Contact Julia Puton
Tel 01992 556441
Email FRMConsultations@hertfordshire.gov.uk

Date 25 February 2019

RE: 6/2019/0085/MAJ – Chancellors School, Pine Grove, Brookmans Park, Hatfield, AL9 7BN

Drawing Title
 SURFACE WATER DRAINAGE STRATEGY
 EXISTING AND PROPOSED
 IMPERMEABLE AREAS

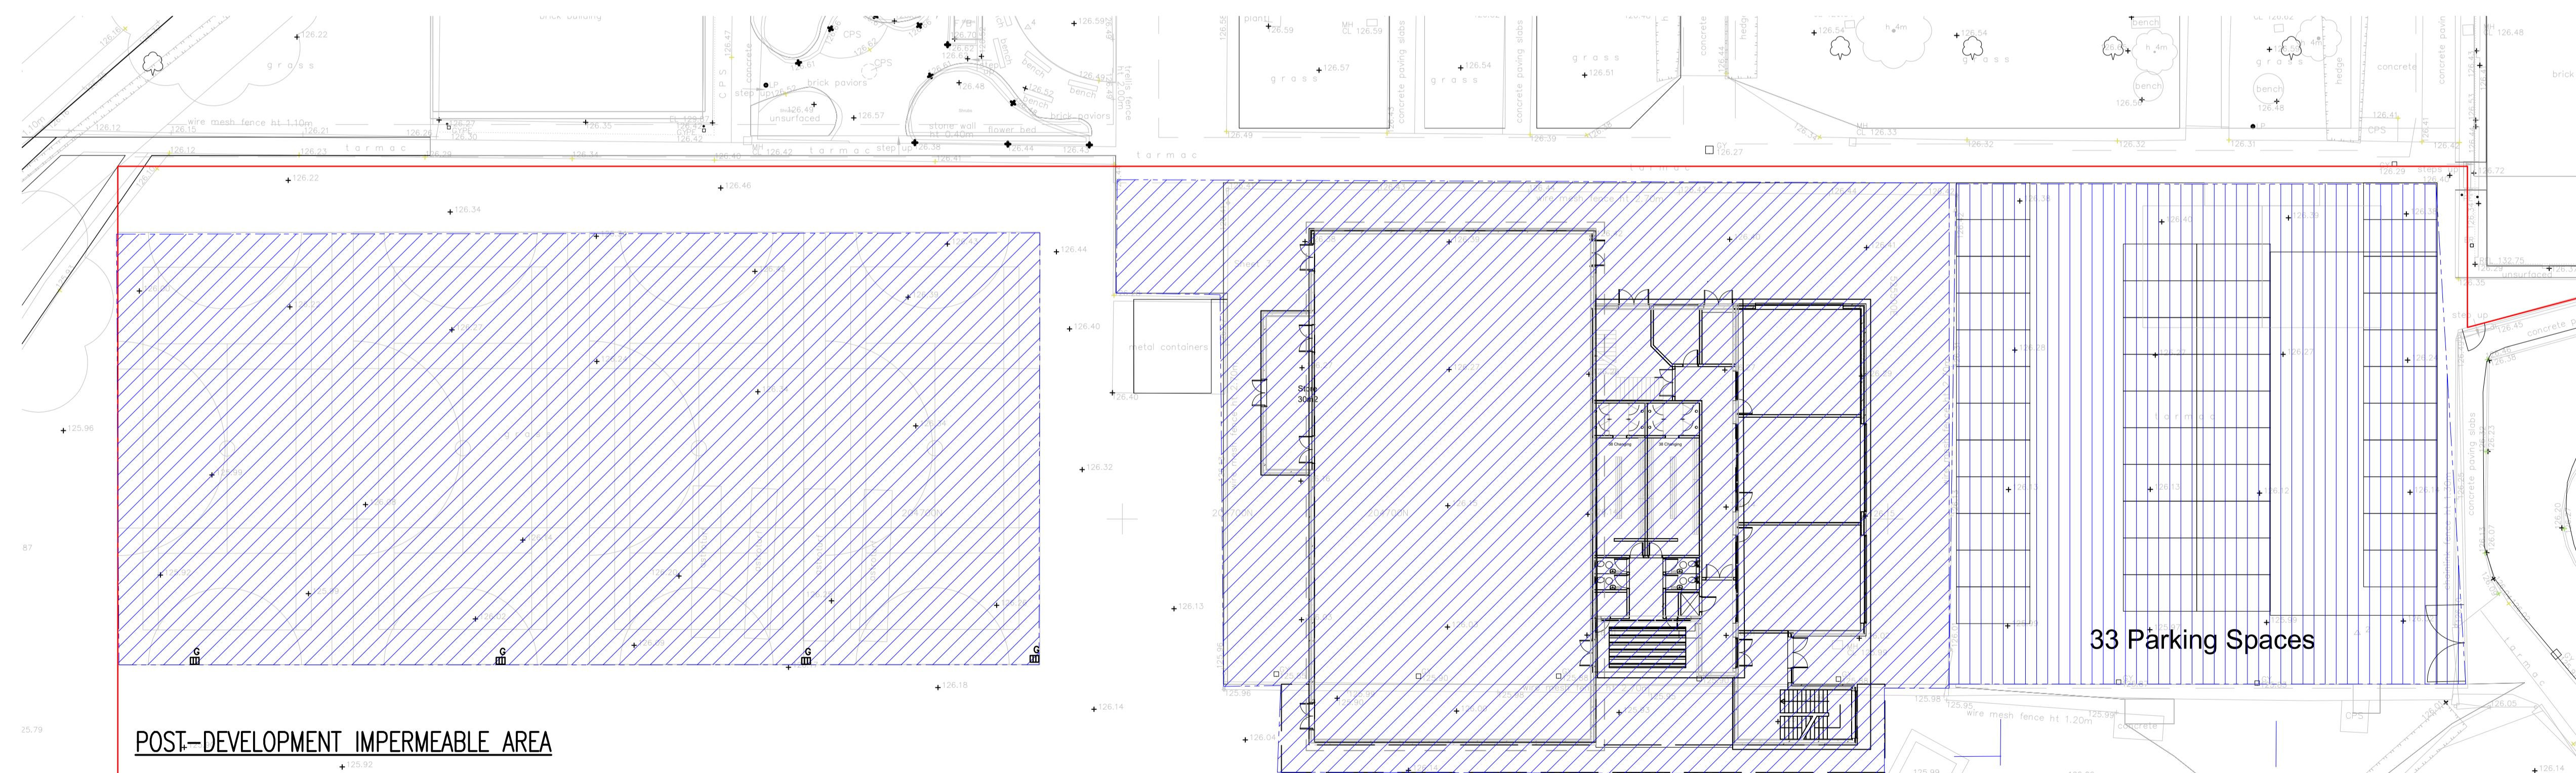
We have reviewed the list of supporting documents and note that a surface water drainage strategy has not been included. In the absence of a surface water drainage strategy, the flood risks resulting from the proposed development are unknown.

Therefore, we object to this application and recommend refusal of planning permission until a satisfactory surface water drainage strategy has been submitted.

7. Full detailed drainage plan including location of SuDS measures, pipe runs and discharge points, informal flooding (no flooding to occur below and including the 1 in 30 Year rainfall return period). All drawings to be 'final' not 'preliminary' or 'draft'.

The applicant can overcome our objection by submitting a surface drainage assessment which covers the deficiencies highlighted above and demonstrates that the development will not increase risk elsewhere and where possible reduces flood risk overall, and gives priority to the use of sustainable drainage methods.
